From: Fiona Fitzgerald
Sent: 17 October 2018 13:41
To: Planning.Responses
Cc: Anita Gardner; Nina Sidhu
Subject: R/209/18/PL 130

Environmental Health note that this is a speculative application and that there is currently no end user in mind. In light of this, EH has **no objection** in principle, but it should be noted that there are three specific issues which would need addressing before first use as A3:

PROPOSED GROUND FLOOR PLAN (A3)
GIA: 123.1 M² / 1325 FT²

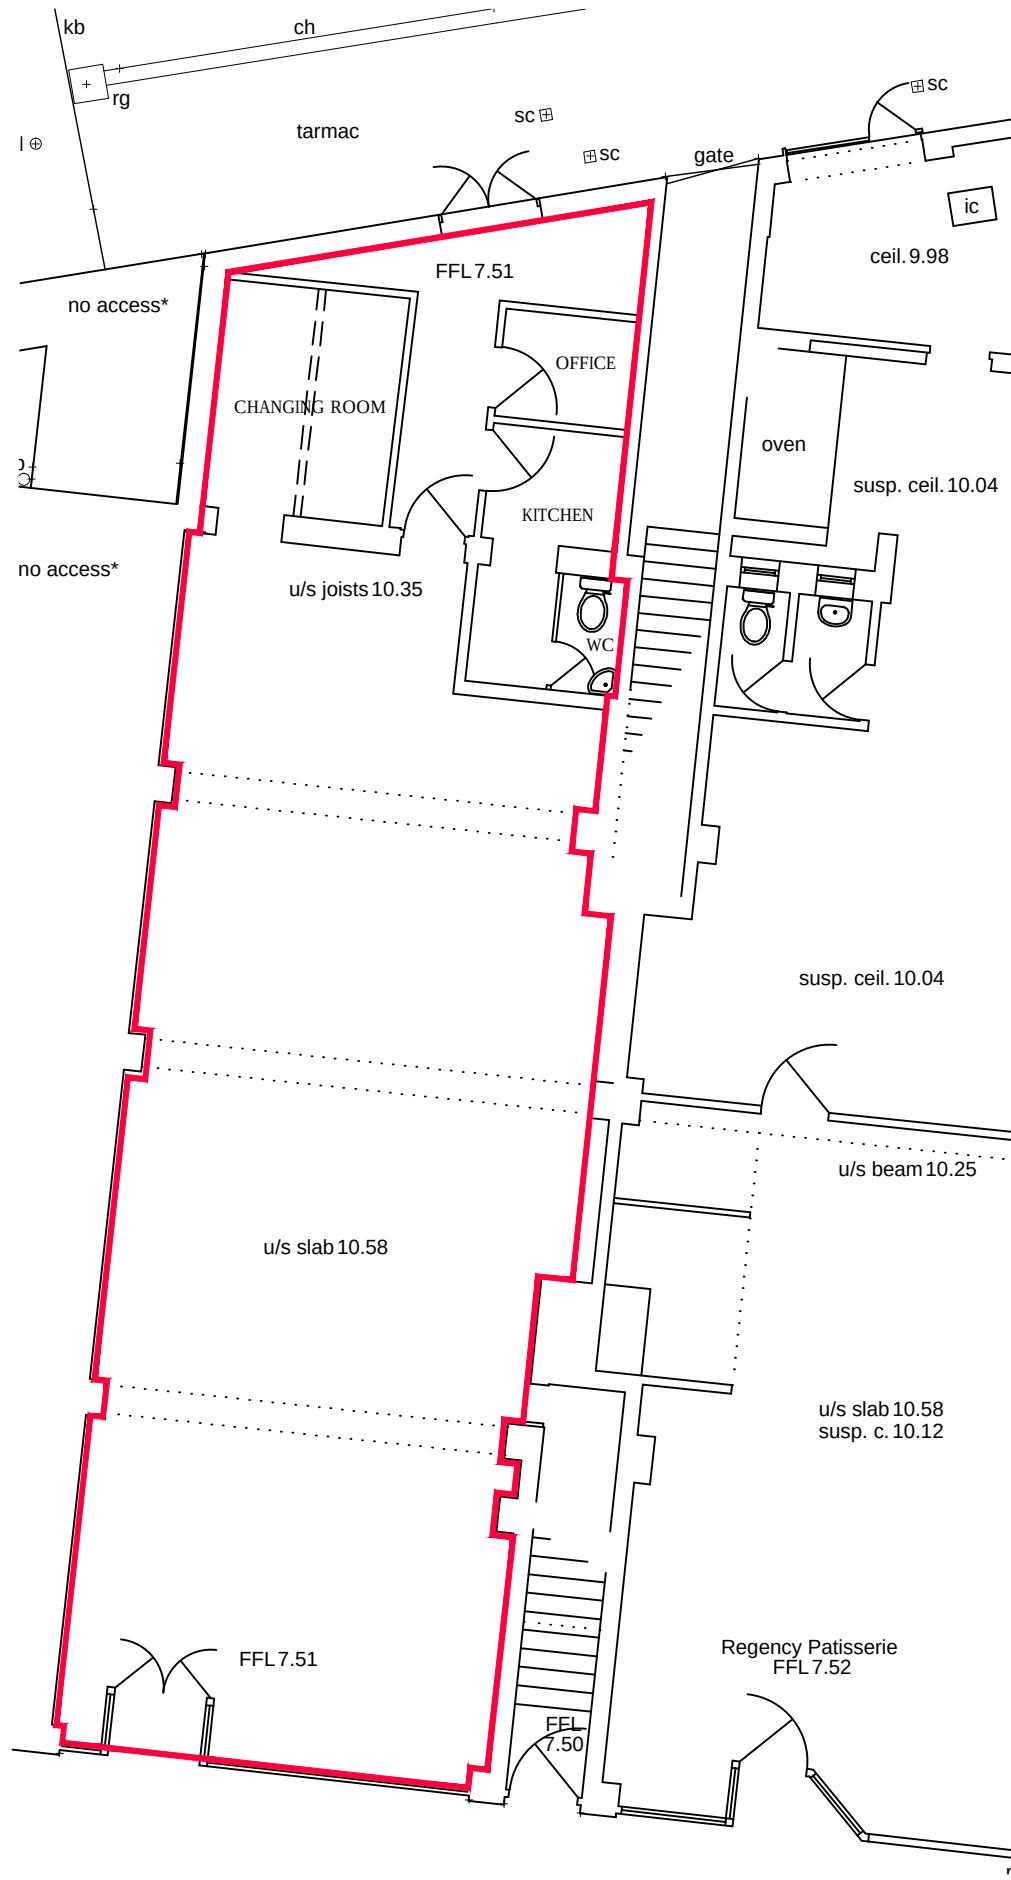
Firstly, there is no information on the kitchen and whether it would comply with current Food Hygiene Regulations. Secondly, the toilet appears to be located within and accessed from the kitchen. This is obviously not appropriate. Finally, there appears to be no sanitary provision for customers.

6. The proposed floor plan currently shows only one toilet in the premises. The numbers of toilets required will depend on the number of staff and covers proposed. Please note the requirements for toilet provision in Arun District which can be found at <https://www.arun.gov.uk/download.cfm?doc=docm93jjjm4n11788.pdf&ver=11779>
7. The granting of this planning permission does not in any way indemnify against statutory nuisance action being taken should substantiated complaints within the remit of the Environmental Protection Act 1990 be received. For further information please contact the Environmental Health Department on 01903 737500.
